Town and Country Planning Act 1990 (As amended)
Town and Country Planning (General Permitted development) Order 2015 Schedule 2 Part 1
Class A

Notification under extended permitted development rights for a single storey extension extending 5m from the original rear wall of the dwelling house, 3.8m high with an eaves height of 2.8m

7 Orchard Way Bognor Regis

BLOCK/SITE PLAN
AREA 90m x 90m
SCALE 1:500 on A4
CENTRE COORDINATES: 493116, 100331

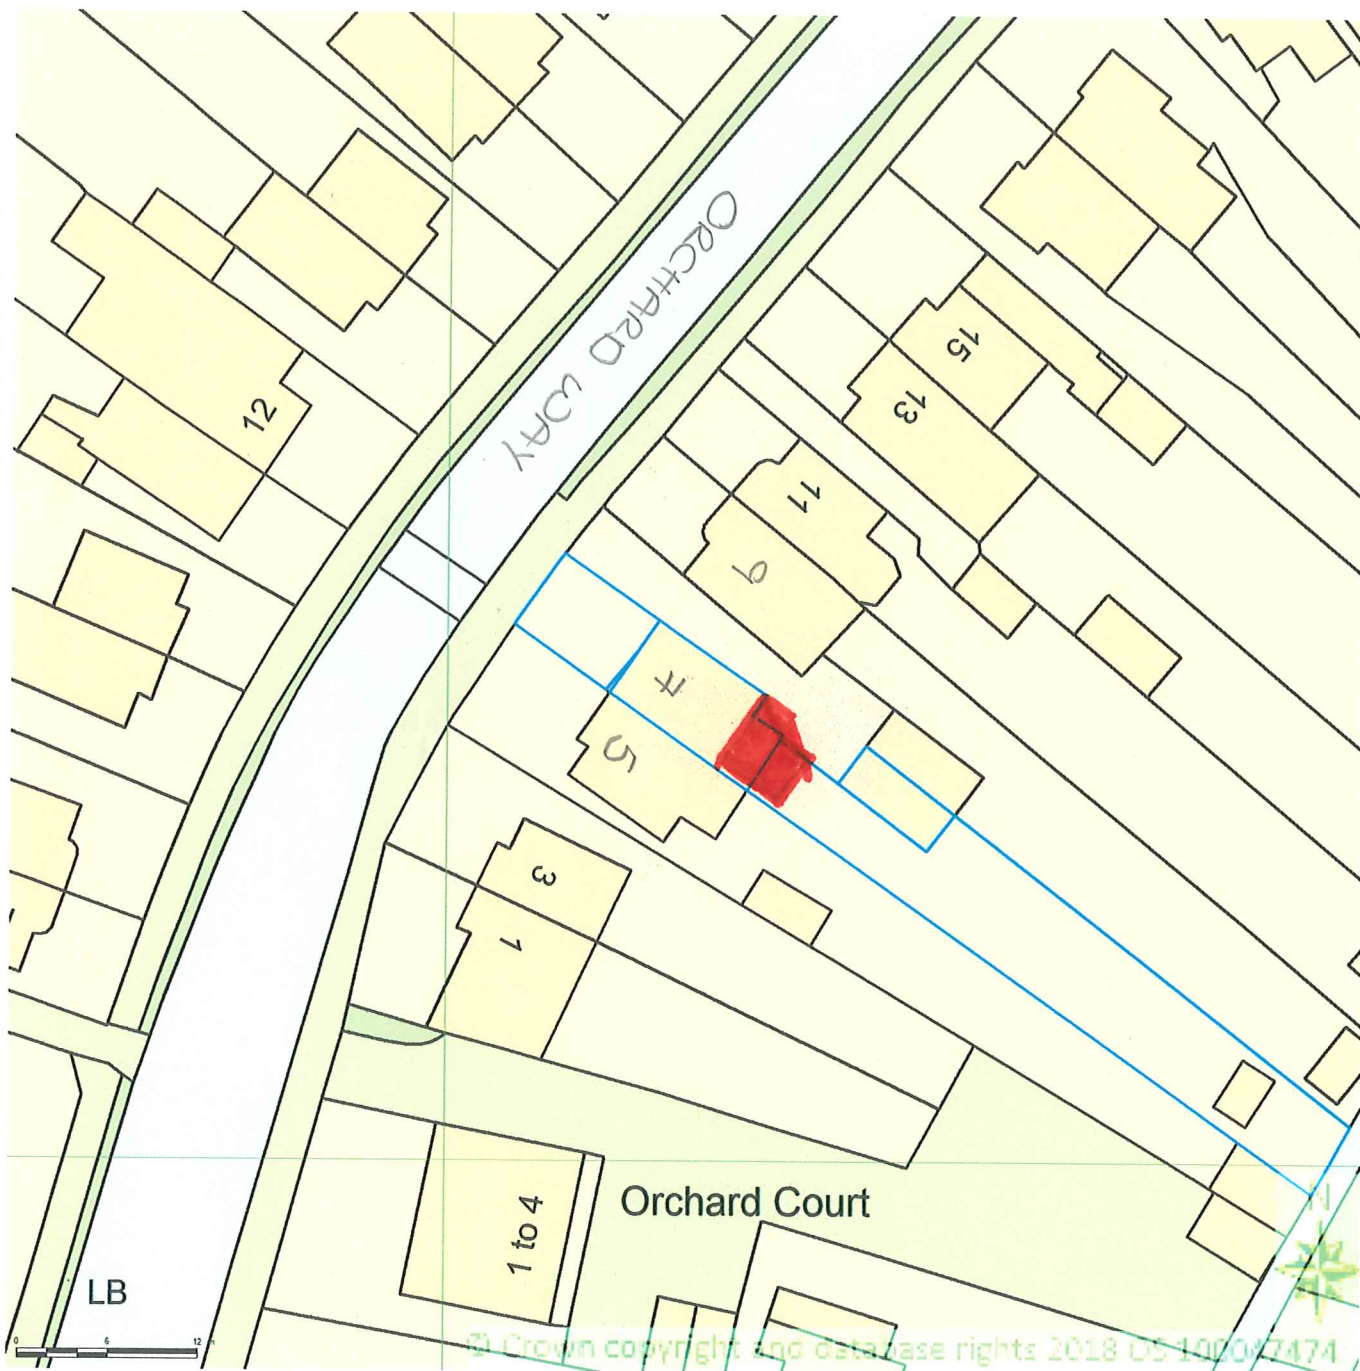
The drawings are very crude and do not give a true representation of the relationship with the existing dwelling let alone any shared boundary. The "elevation" is so poorly drawn, you cannot tell how it relates to anything! This appears to be constructed on the boundary and I would be asking whether it can actually be built on land entirely within the applicant's ownership? I would therefore suggest that there is insufficient information to assess the full impact of the proposed development on the amenity.
